Welwyn Hatfield Borough Council

Application for a non-material amendment following a grant of planning permission.

Rev.	Date	Notes	By	Chk
Clouded Areas Indicate revisions since last issue				
work stage		Preparation and Brief		
drawing status		Approval		
job no. + work stage + building + drawing no.				revision
2142 / 03 / 0015				-

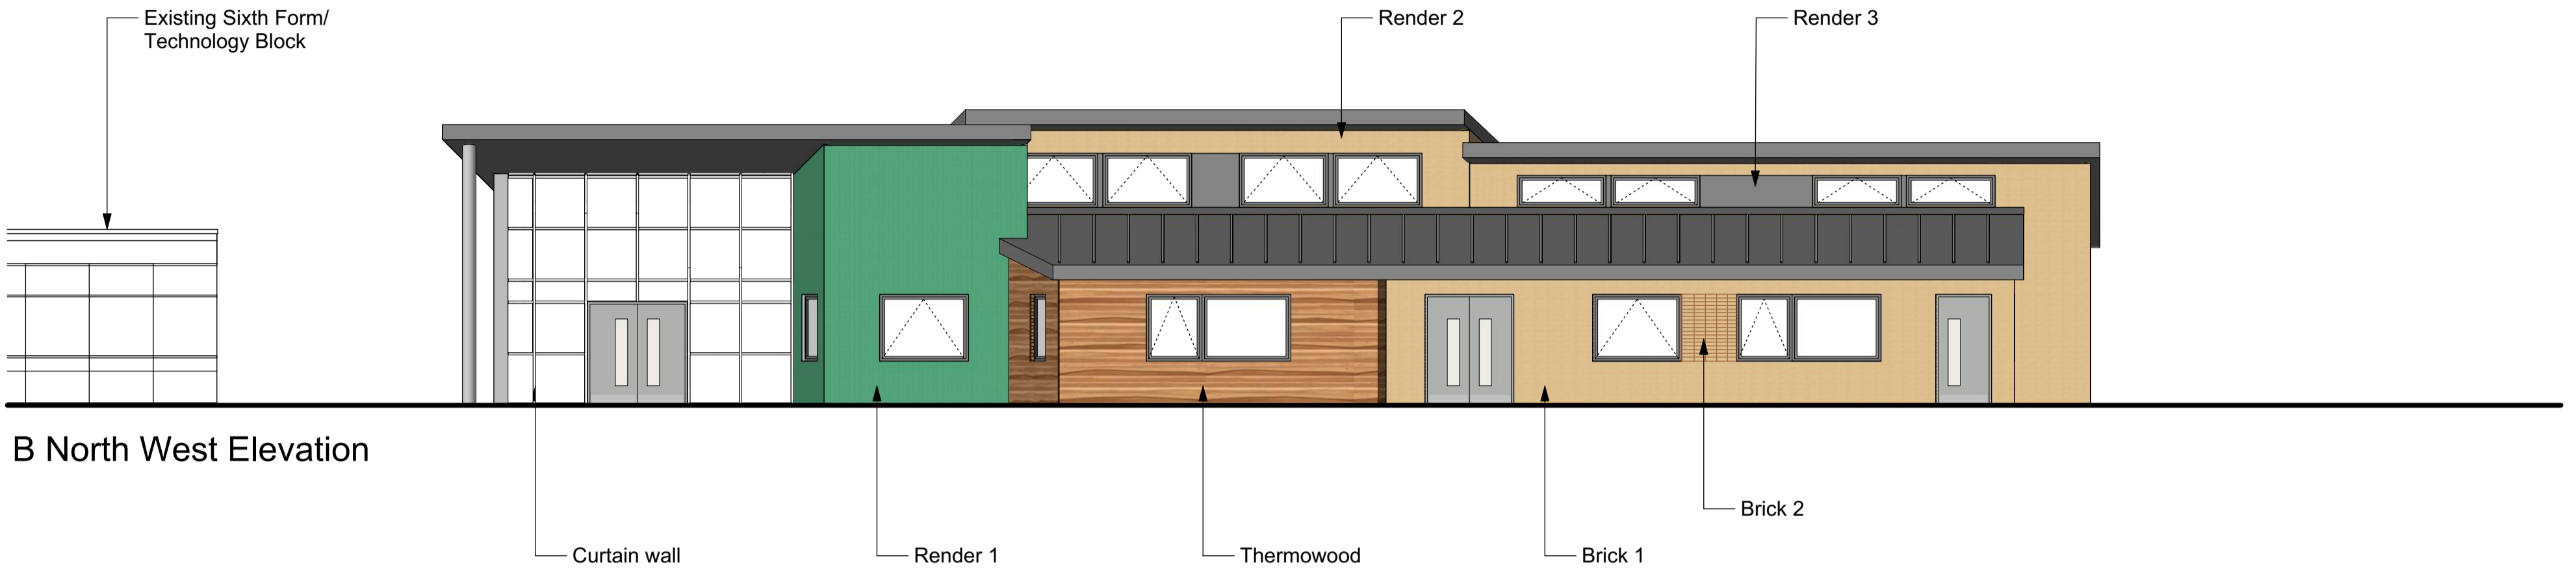
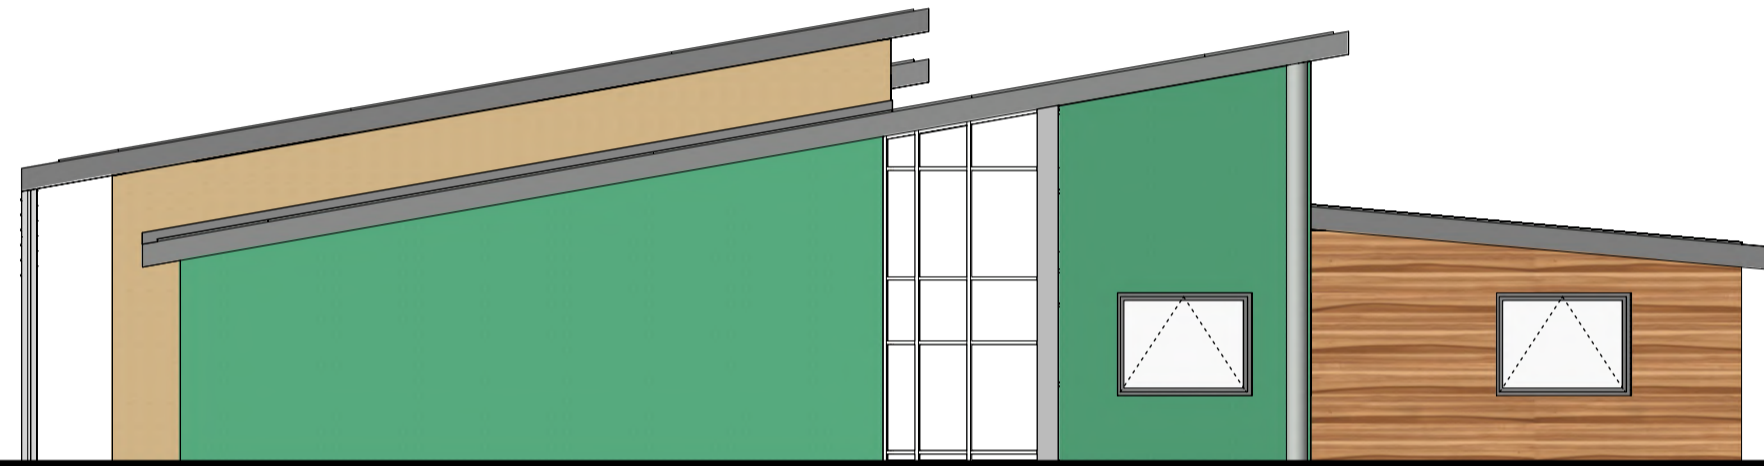
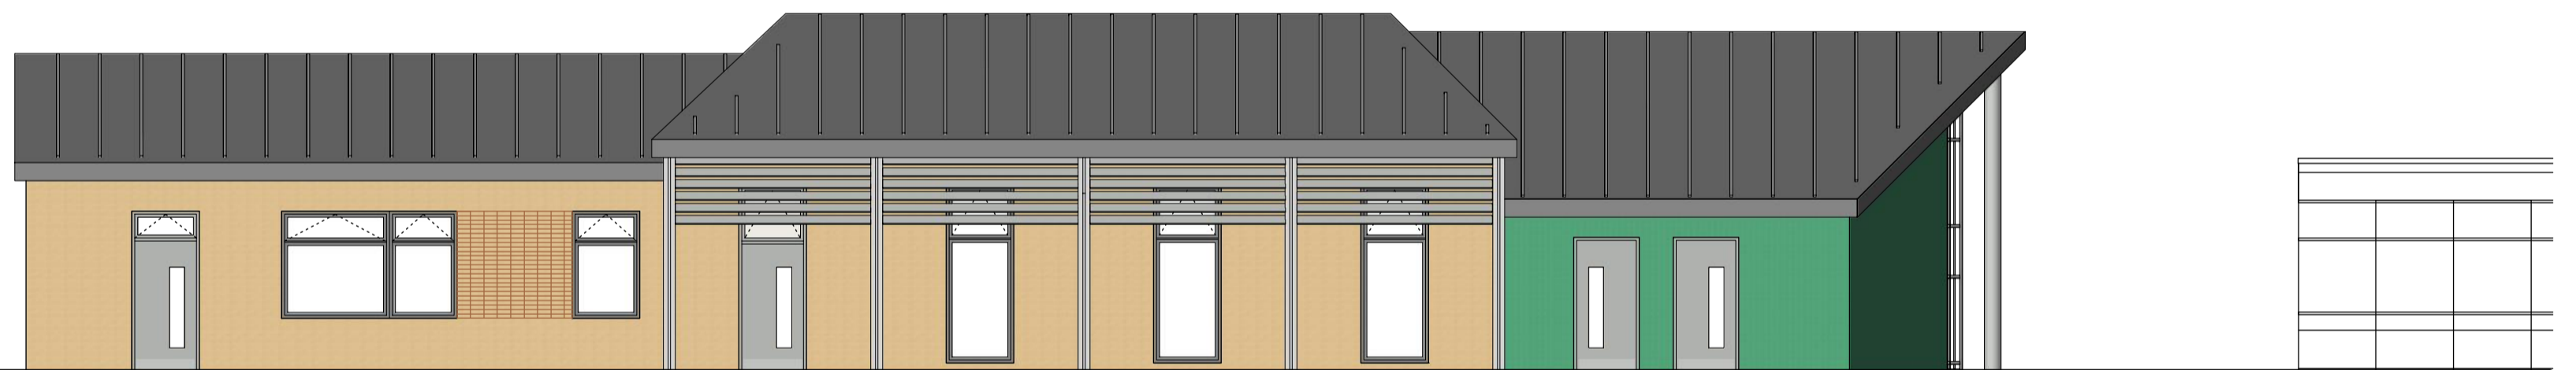
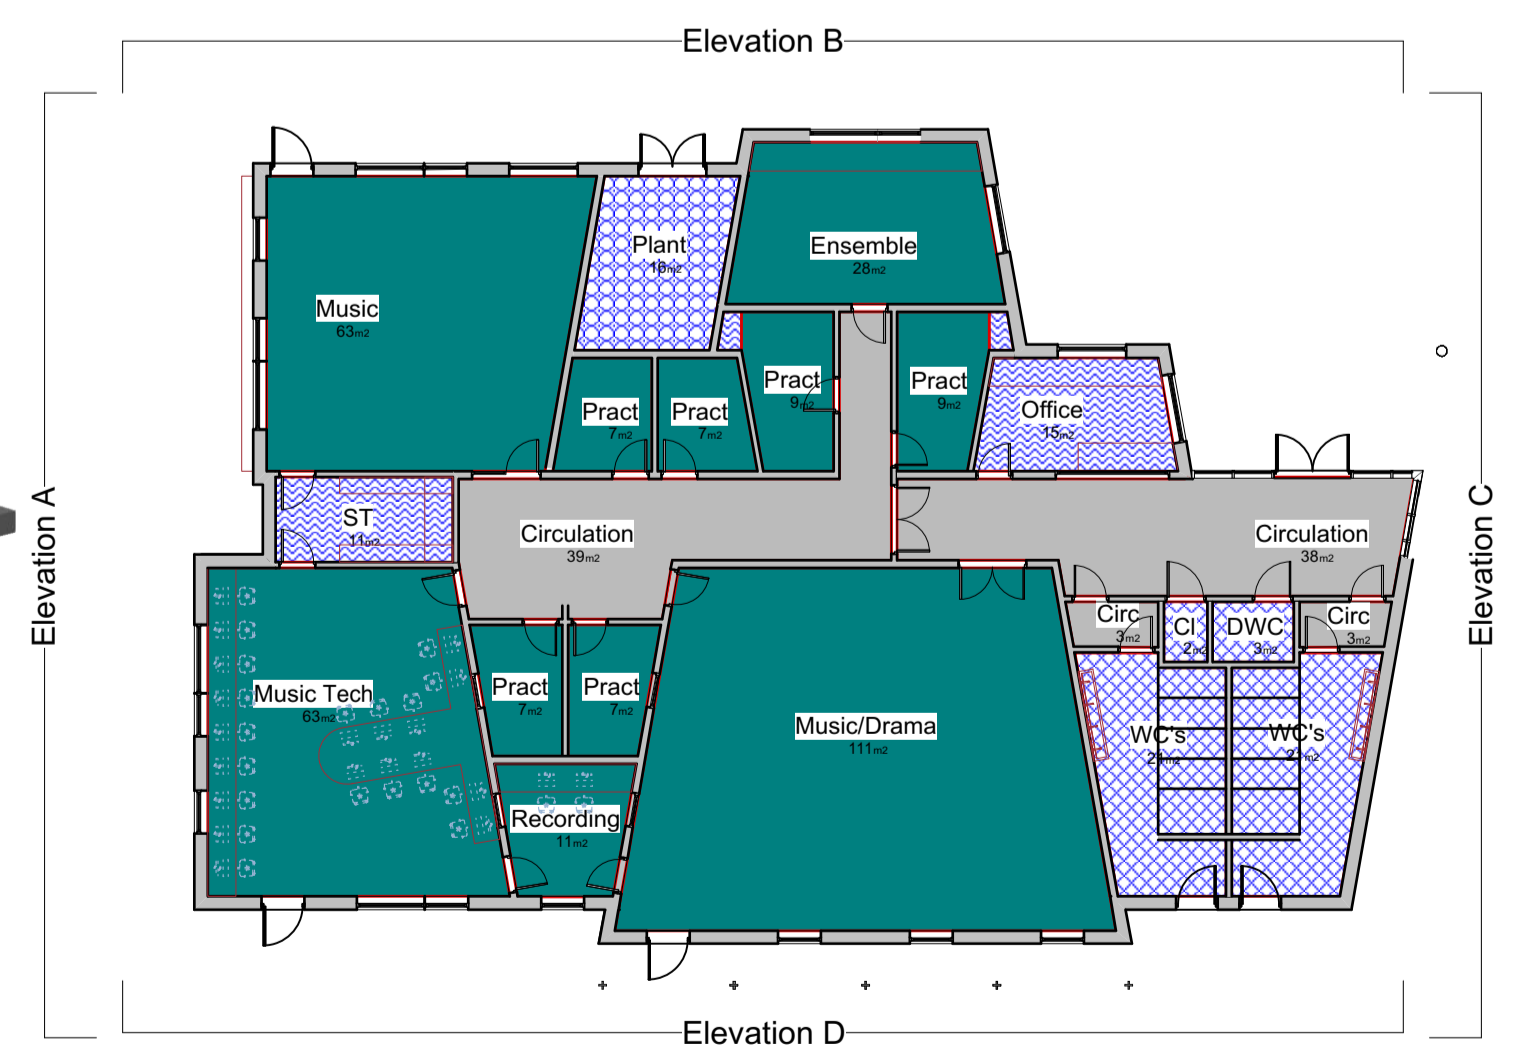
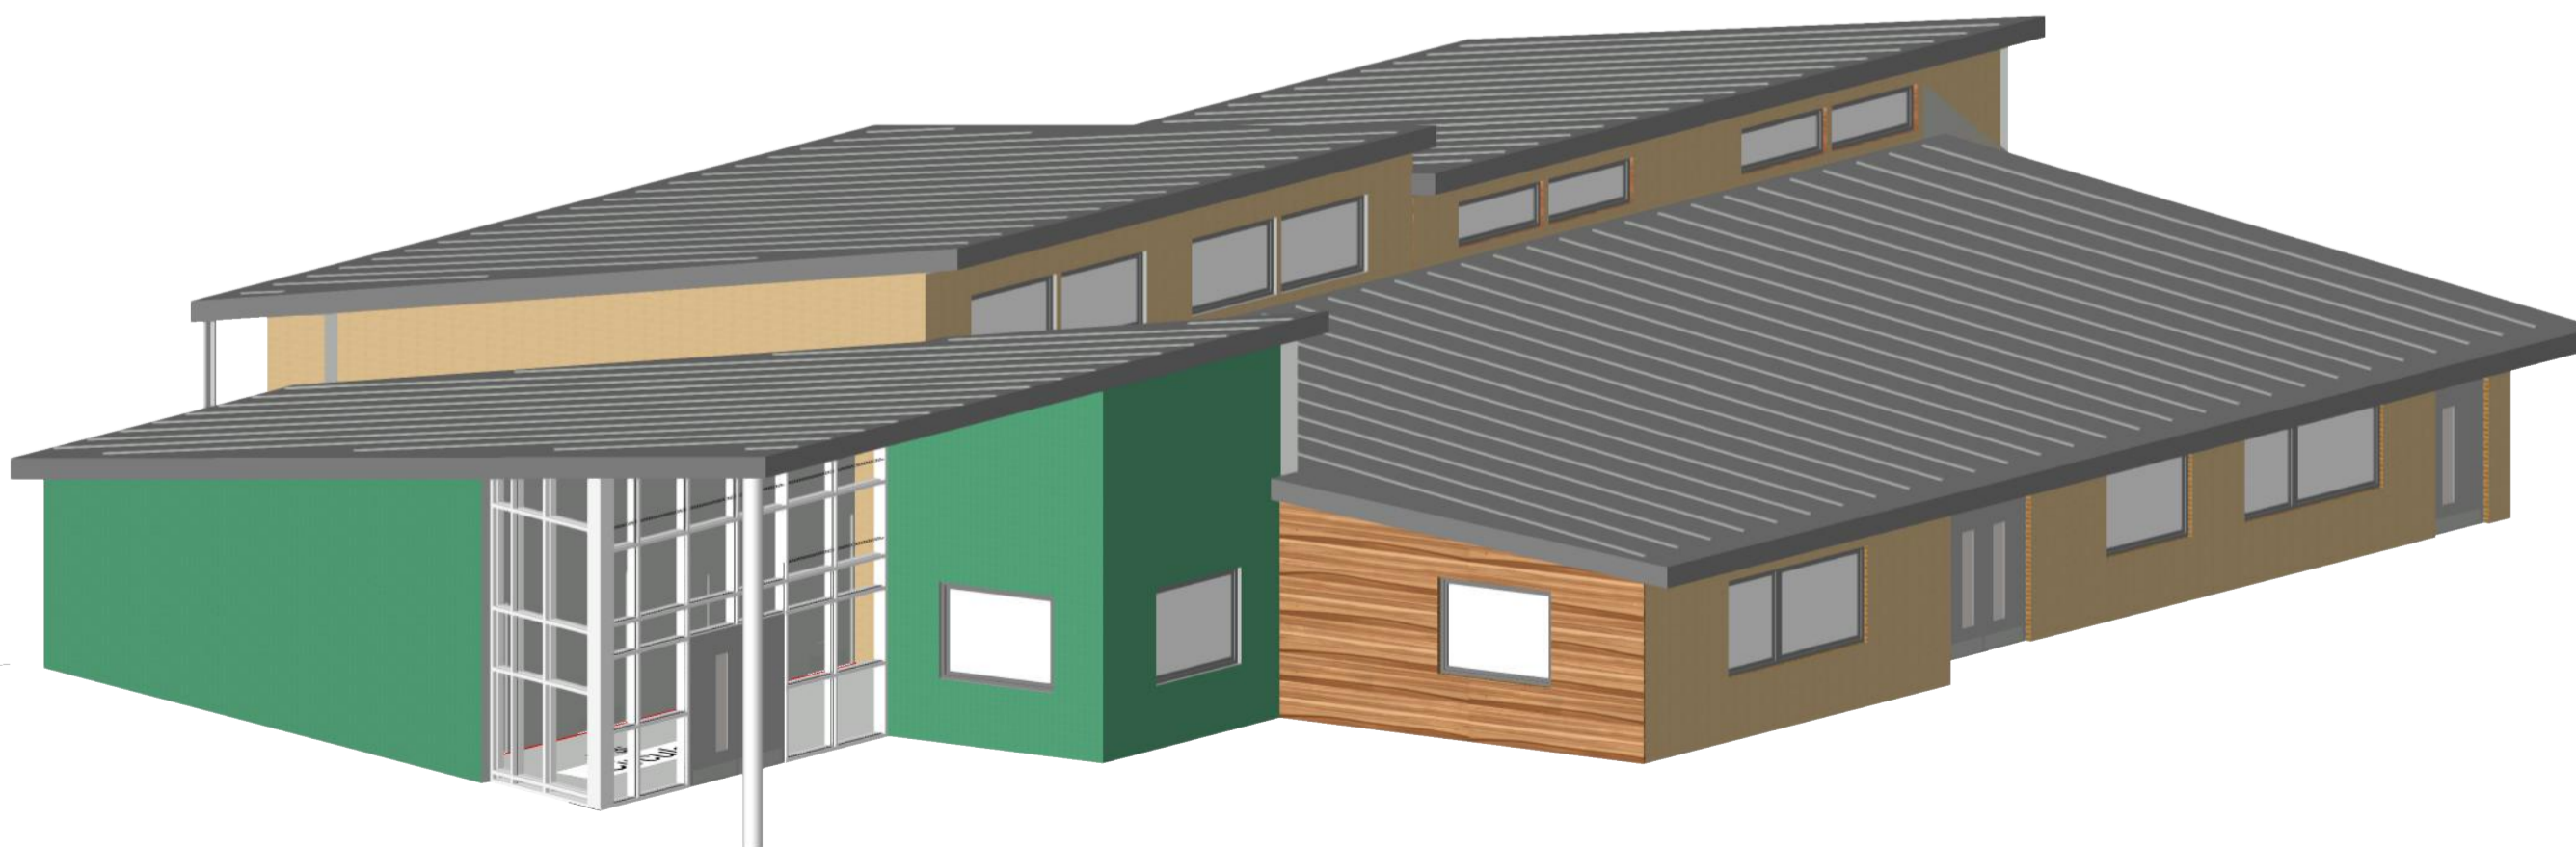
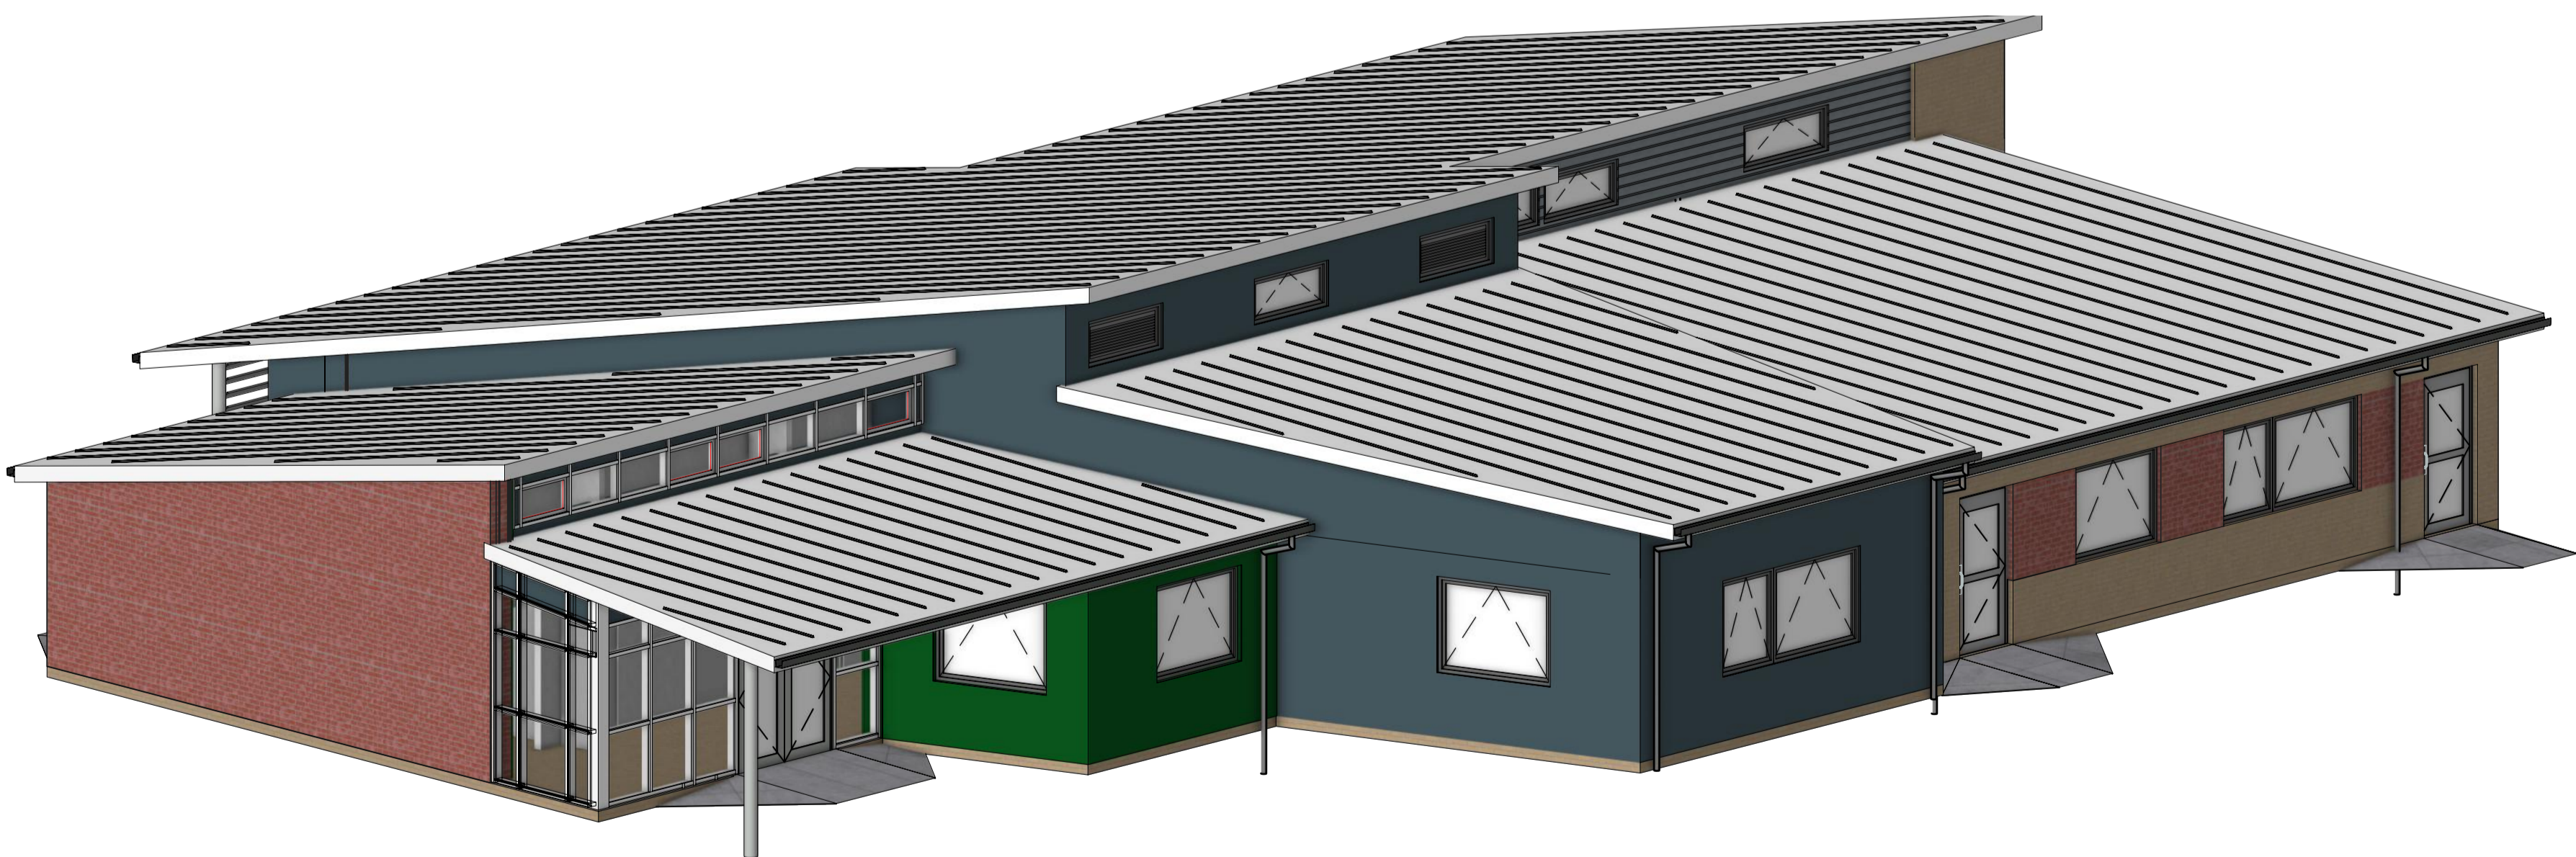
Internal alterations with associated changes to fenestration and roof profiles. Rationalisation of external materials.

Delay in obtaining funding and changes in school leadership team have led to value engineering to rationalise room heights and roof profiles, resulting in a reduced overall building height, together with internal alterations to better reflect current and future needs. Resultant changes in room layout and roof profiles has led to minor variations in external door and window configurations. Building location, footprint and occupancy remain unchanged from the approved drawings.

2142/03/0010B - Proposed Music Block Floor Plans  
2142/03/0015A - Proposed Music Block Elevations
